Re: Certification Submittal for Final Building Certificate of Occupancy for  
Furniture Row, [H16 / D117A]  
SW Corner of Wellesley and Menaul  
Engineer's Stamp Dated

RE: FURNITURE ROW (H-16/D117A)  
(Menaul & Wellesley NE)  
ENGINEERS CERTIFICATION FOR CERTIFICATE OF OCCUPANCY  
ENGINEERS STAMP DATED 1/11/2001  
ENGINEERS CERTIFICATION DATED 10/2/2001

RE: FURITURE ROW (H-16/D117A)  
ENGINEERS CERTIFICATION FOR CERTIFICATE OF OCCUPANCY  
ENGINEERS STAMP DATED 01/11/2001  
ENGINEERS CERTIFICATION DATED 9/26/2001 (For Temporary C.O.)

**Re: Furniture Row Grading and Drainage Plan**  
**Engineer's Stamp dated 1-10-01 (H16/D117A)**

SHEET NAME
TRAFFIC CIRCULATION LAYOUT PLAN

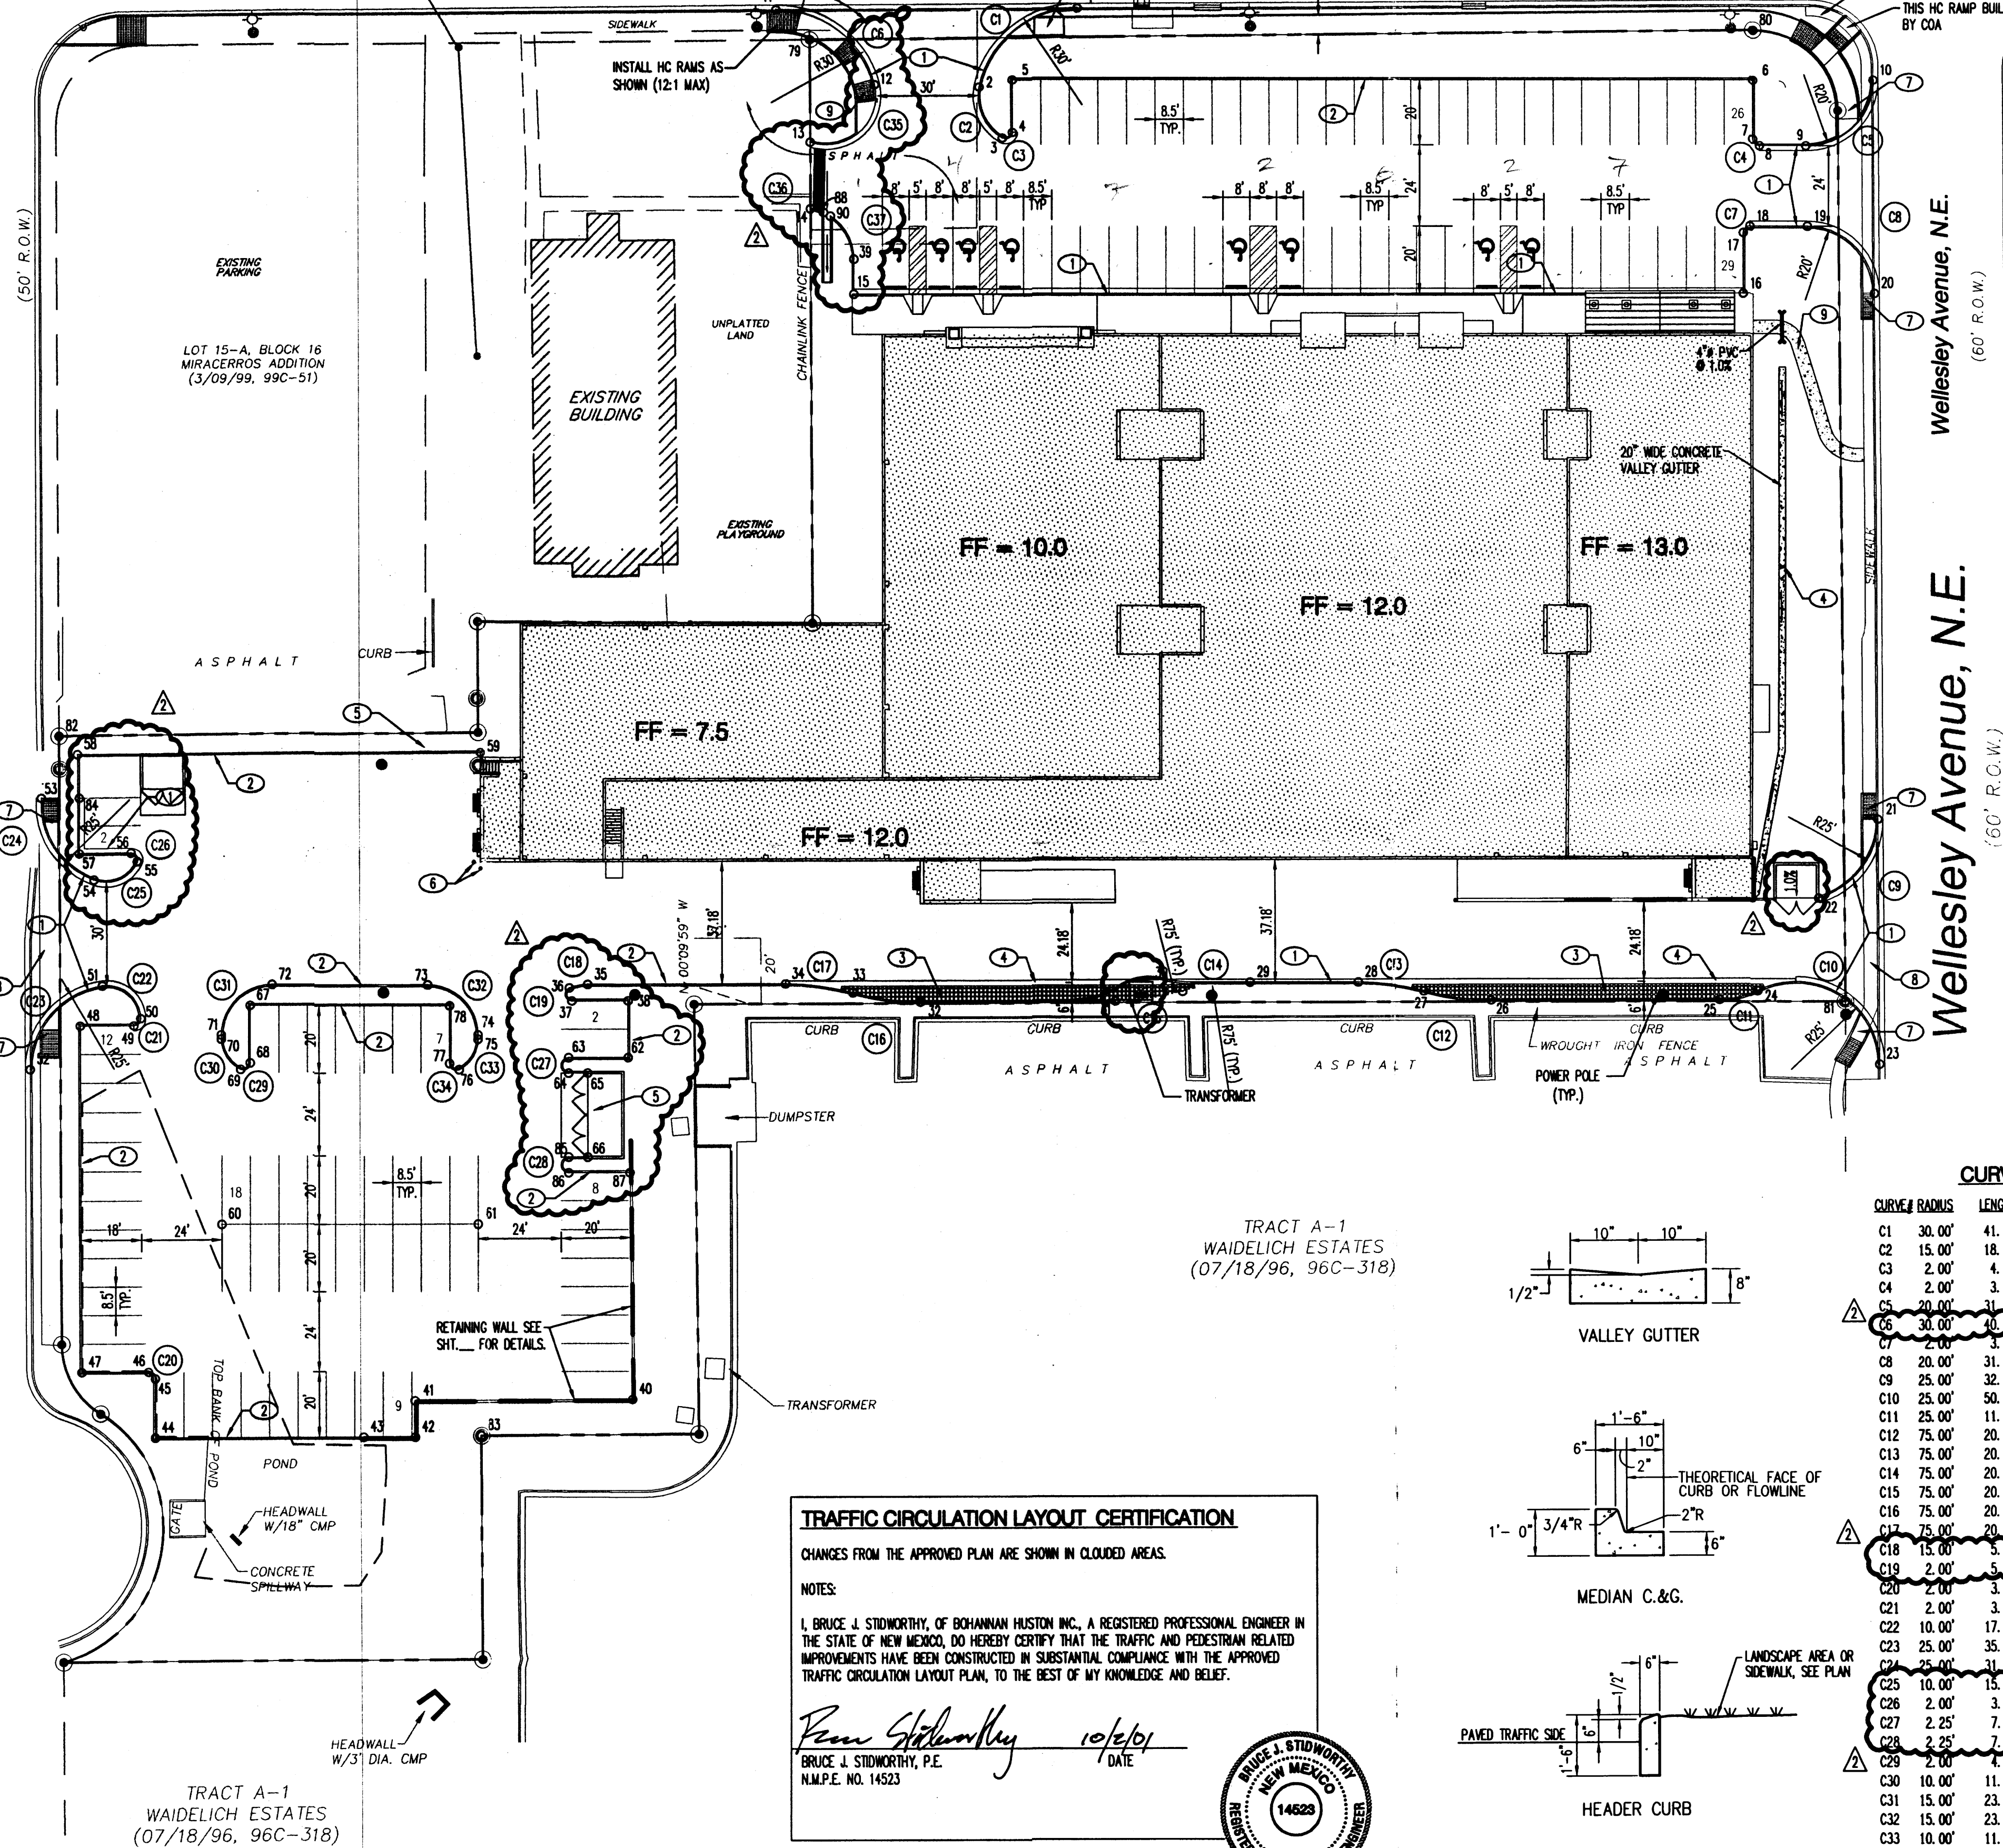
*10/1/01  
no problem  
Don't worry  
about it.* A Temporary Certificate of Occupancy has been issued for 30 days, allowing resolution of the outstanding issues: 1) Field verification of site has shown that sidewalk on Wellesley Ave. was not constructed per approved plan or the sidewalk ordinance. This will have to be redone. 2) In order for access the site to the west a cross access agreement will need to be recorded at the County Clerk's Office at the Albuquerque City/County Government Building. Copy of the easement is needed. 3) Completion of striping. 4) H.C. signage, and 5) Slope adjustments in H.C. areas as mentioned.

10/19/01 - Verified in Basement [Menaul TNBP.doc] - Not App'd T.C.L.  
Many unapp'd Changes on Plan for T.C.L.

Once the issues above have been fully completed, are in substantial compliance, and a final Certification has been resubmitted to the City's Hydrology office for approval, a Permanent Certificate of Occupancy (C.O.) will be issued.

SHEET NAME
GRADING/DRAINAGE PLAN

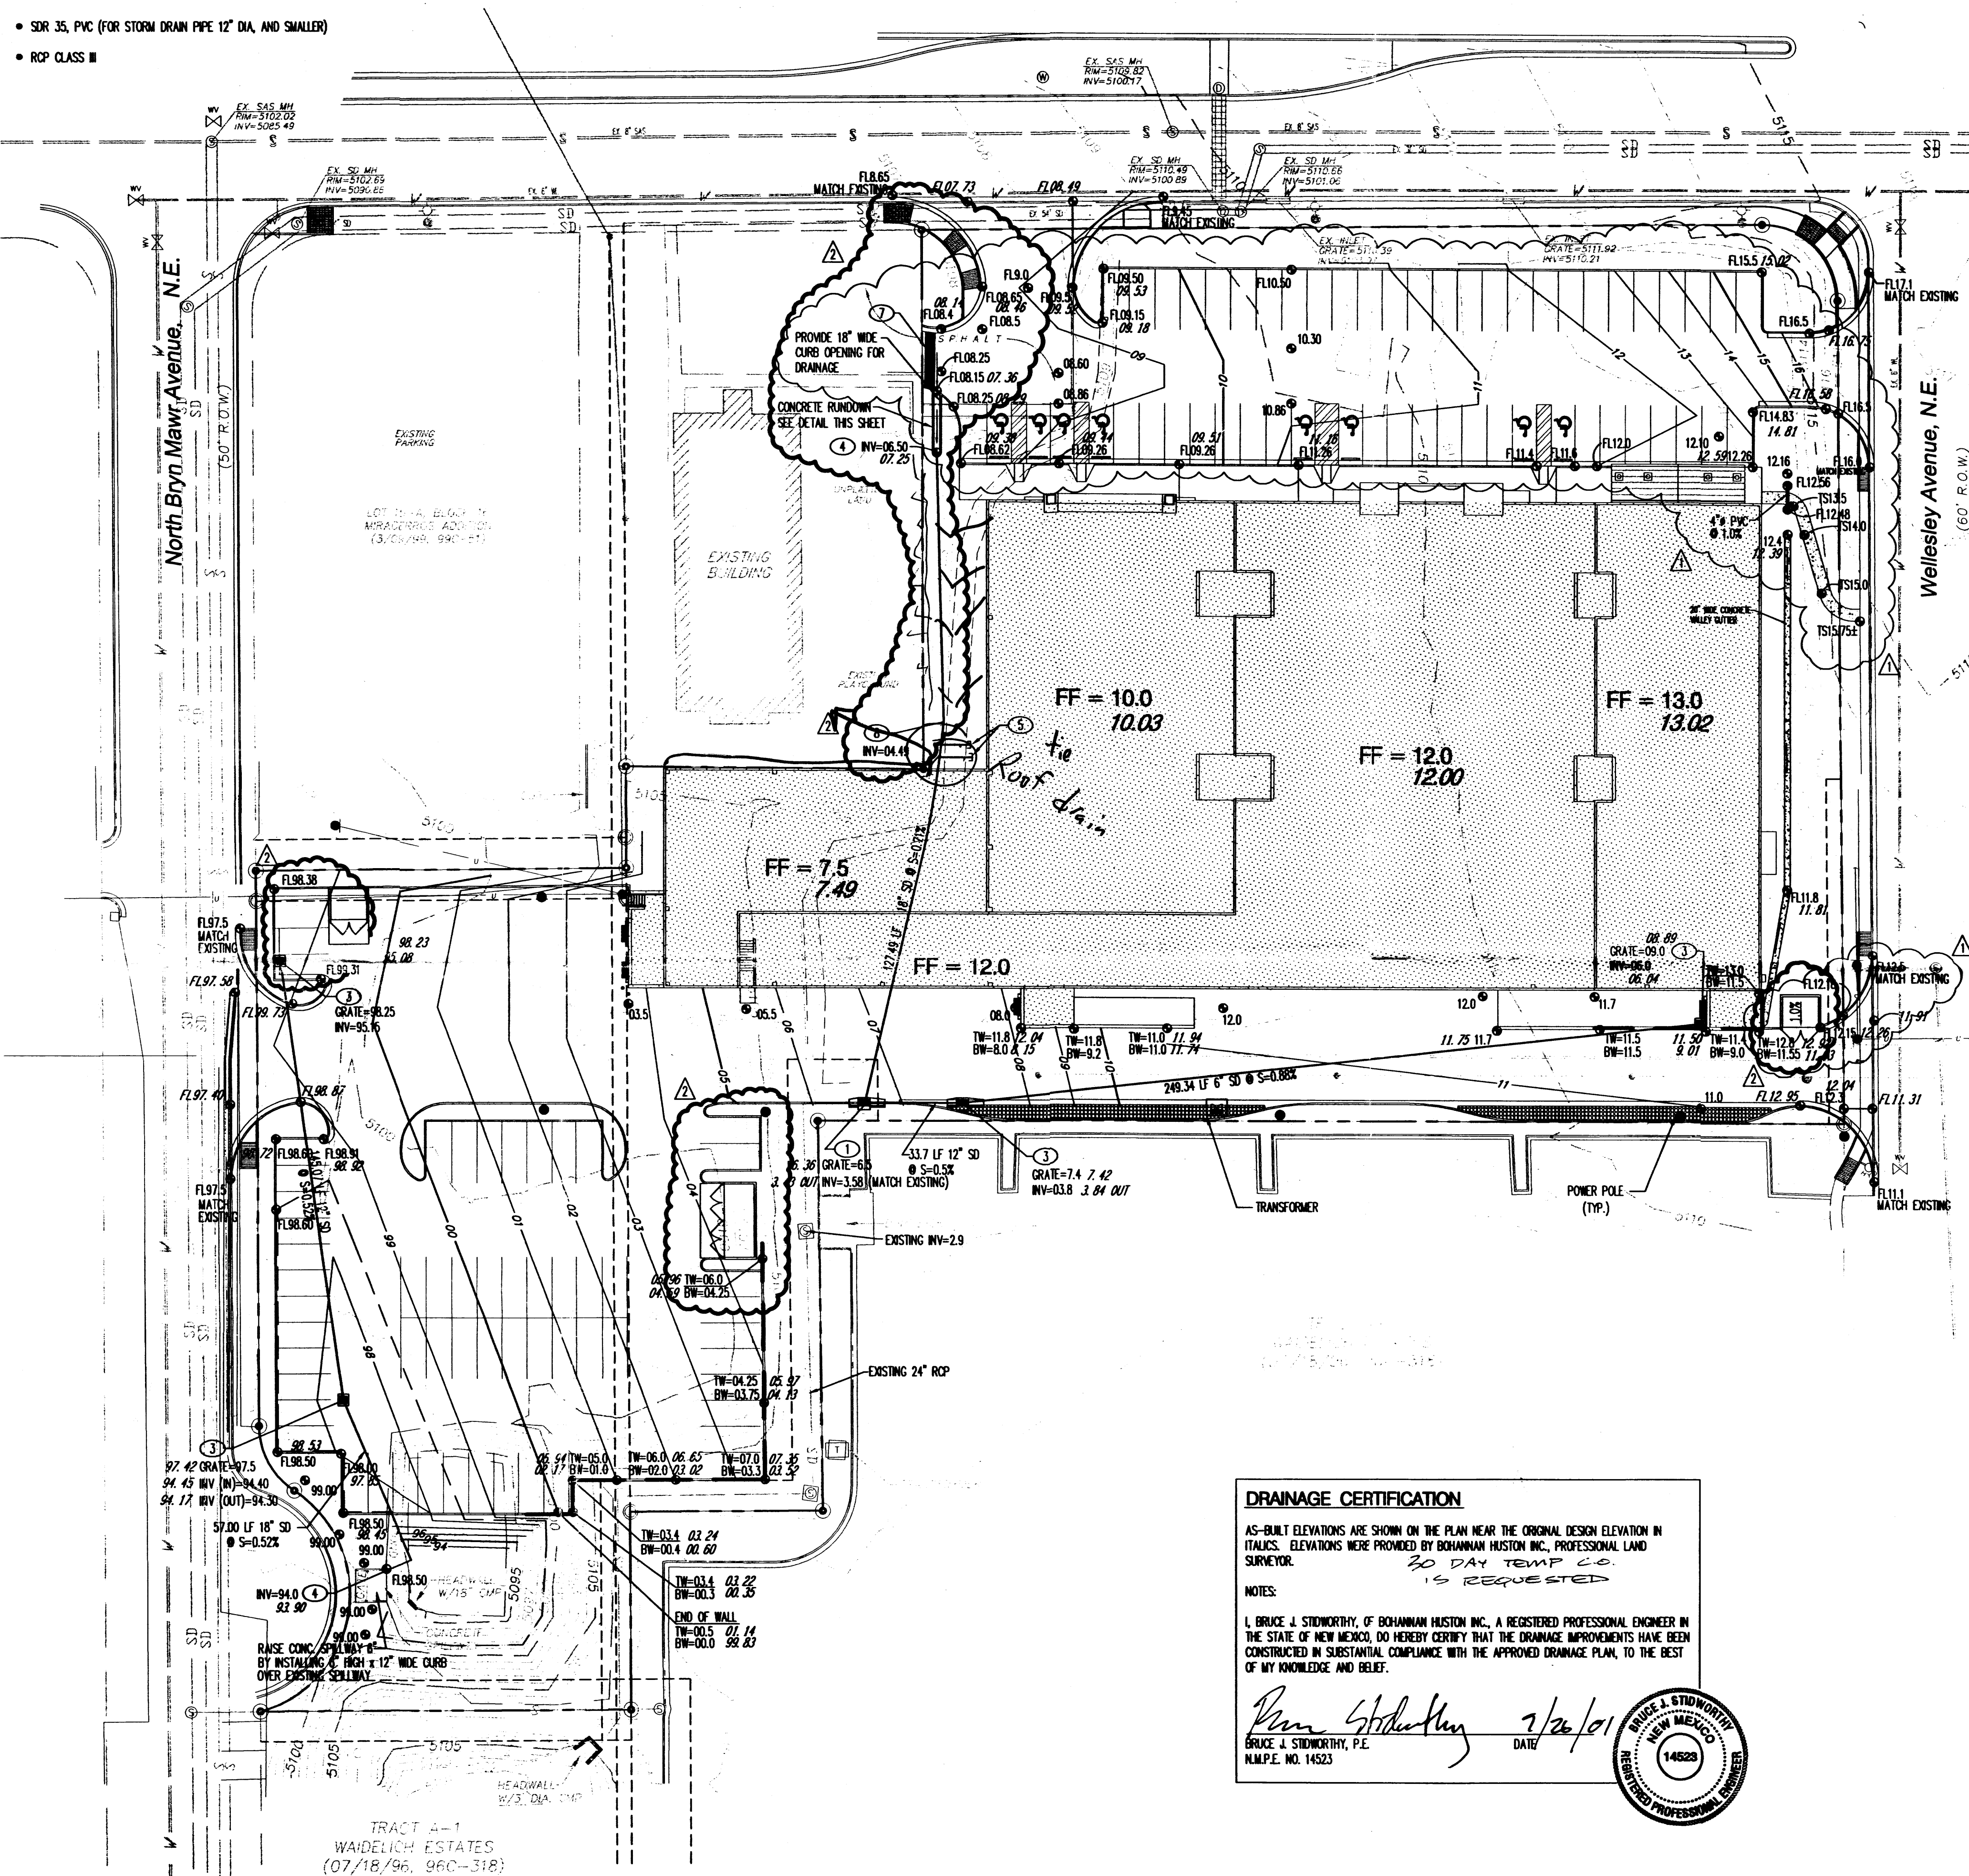
A field inspection of the site was conducted, and it was found to have some drainage deficiencies. A tie-in to the roof drain must be constructed; Also a drainage complaint from the adjacent property owner was received for offsite flows onto their property must be resolved prior to a Certificate of Occupancy being issued.

- No offsite topography is shown on the plan. It would be helpful in assessing the offsite impact to the subject property.
- *why* The existing pond and storm drainage system must have some runoff impacting it under current conditions. These conditions must be assessed and compared to the fully developed conditions.
- No storm drainage or inlet calculations are shown on the plan. —
- The plan shows a single 18-inch storm drain under the proposed building. *no choice*
- What is the flow rate impacting the proposed concrete rundown. Does it have adequate capacity? No calculations were found on Plan. *trial*
- The pond on Tract A-1 should be addressed and rating curves should be included on Plan if new runoff is intended to impact this pond. *same as before*

When the outstanding drainage issues have been resolved and an Engineers Certification has been resubmitted to our office, a Certificate of Occupancy can be issued.
